**Re: Health Care for the Homeless, 1220 First Street NW
Traffic Circulation Layout**
Architect's Stamp dated 9-26-14 (J14-D172)

Thank you for your updated site plan based on prior comments. Based upon the information provided in your submittal received 10-29-14, the following comments need to be addressed prior to approval for Building Permit:

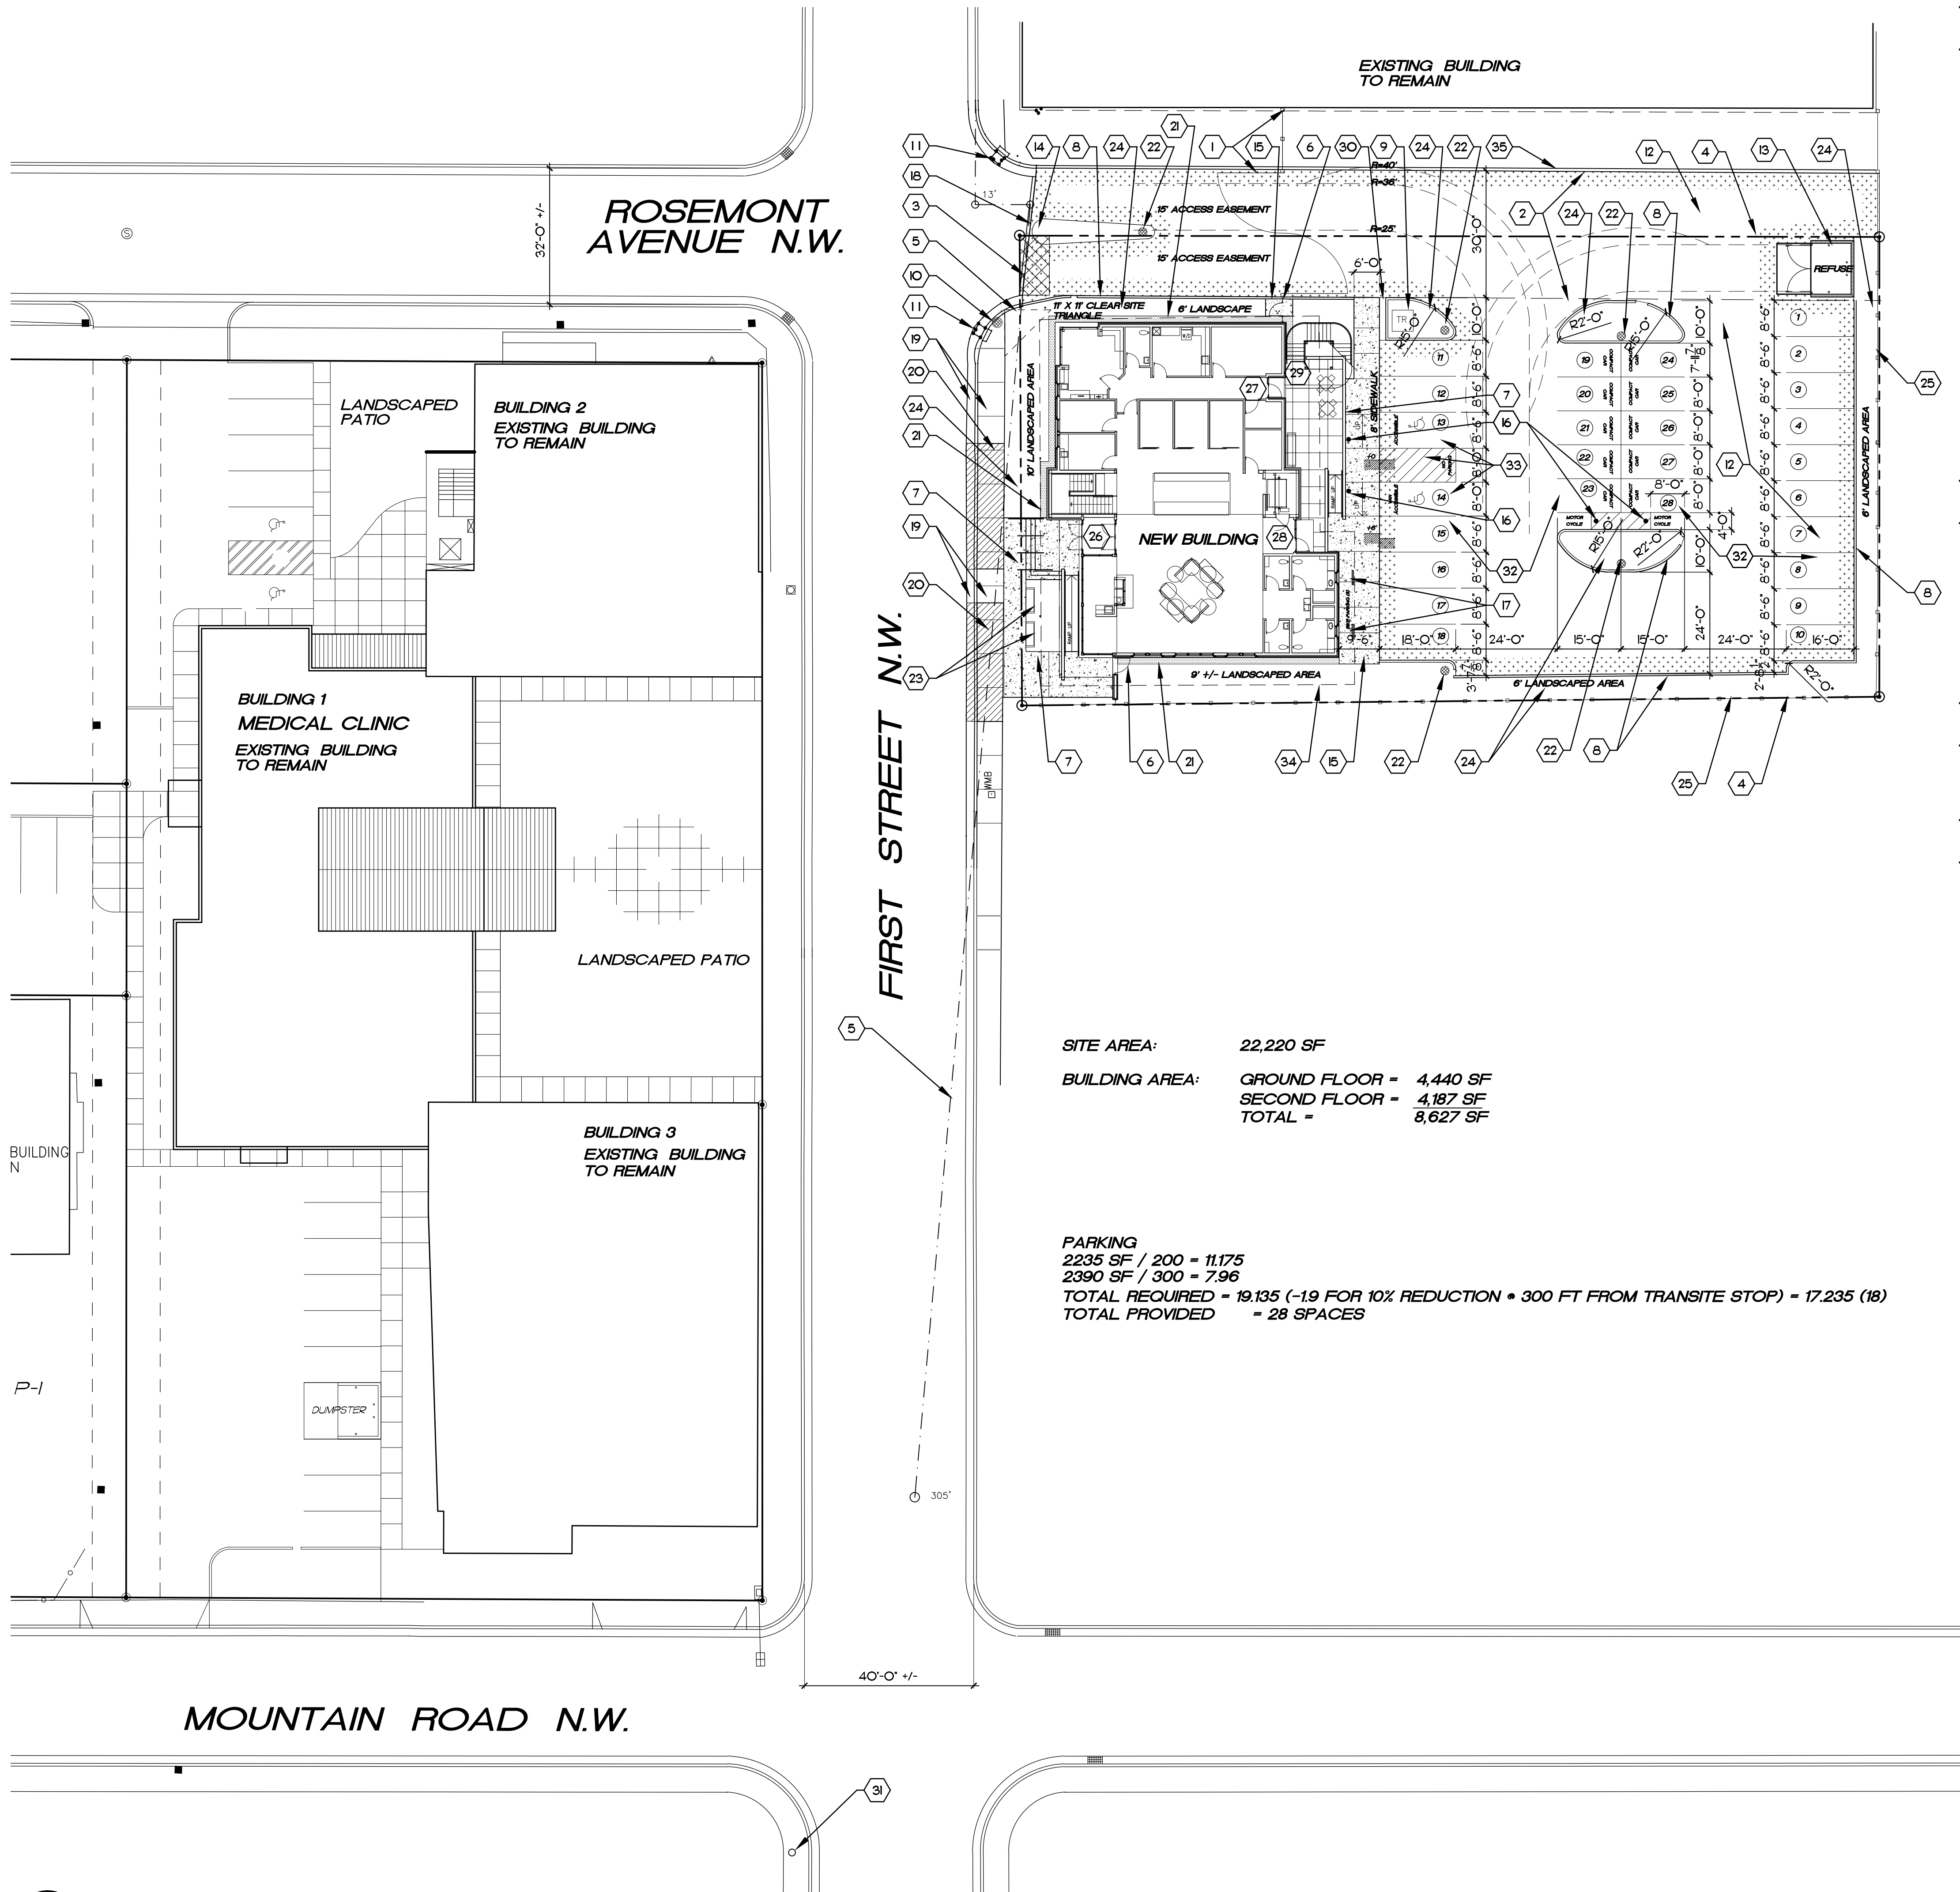
2. The wheelchair ramps across the 30-foot access easement look good in concept along with some of the dimensions that were added. However, the City of Albuquerque is unable to approve the site plan showing that the remaining construction details can be worked out in the field. Show the remaining details including remaining wheelchair ramp and truncated dome area dimensions, proposed easement dimensions, required slopes, and dimensioning and call-out of header curb. (The proposed spot elevations look like they will work to provide the required 2% cross-slope across the 30-foot access easement. Proceed to call out the 2% maximum cross-slope across the 30-foot easement.) Provide this detail within the set of plans.
